From: Andrew Wood
Sent: 01 May 2019 11:10
To: Lynnyrd Wolfe
Subject: FW: F/4/19/PL - Mild Steel Vehicle Store at Ford Depot Station
Attachments: 0996_001.pdf

F/4/19/PL - Mild Steel Vehicle Store at Ford Depot Station

Front Elevation (External)

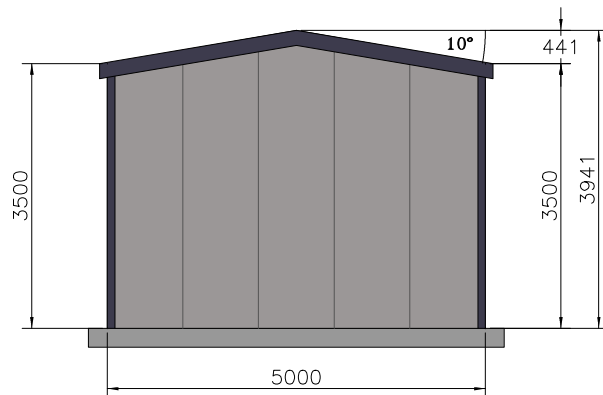
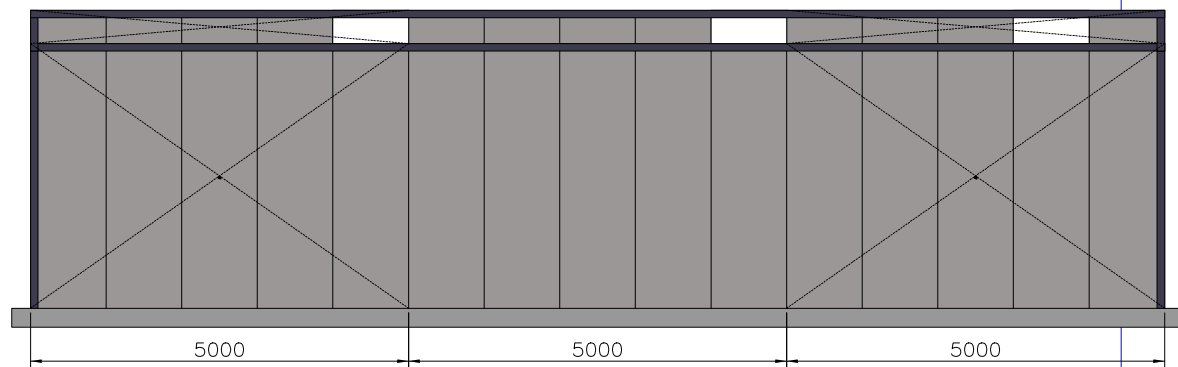
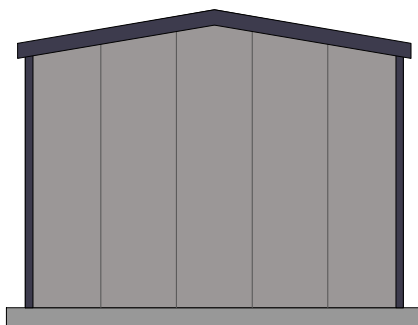
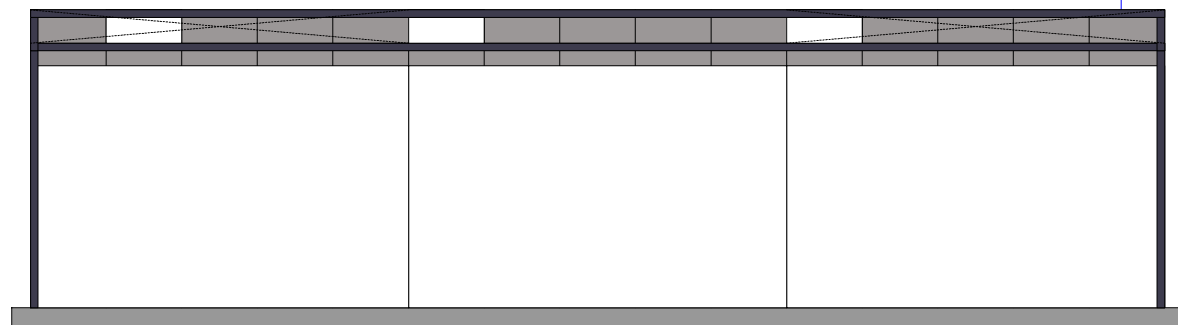
Could you please provide details of the colour of the proposed mild steel building.

It is in the full view of users of the Arundel to Littlehampton Green Link and therefore it is considered that the building should match in colour other buildings i.e. painted green and be sympathetic in colour with the surrounding landscape in accordance with policy D DM1 of the Arun Local Plan.

I can confirm that the Vehicle Store at Ford Depot will be painted green in keeping with the rest of the environment agency depot structures.
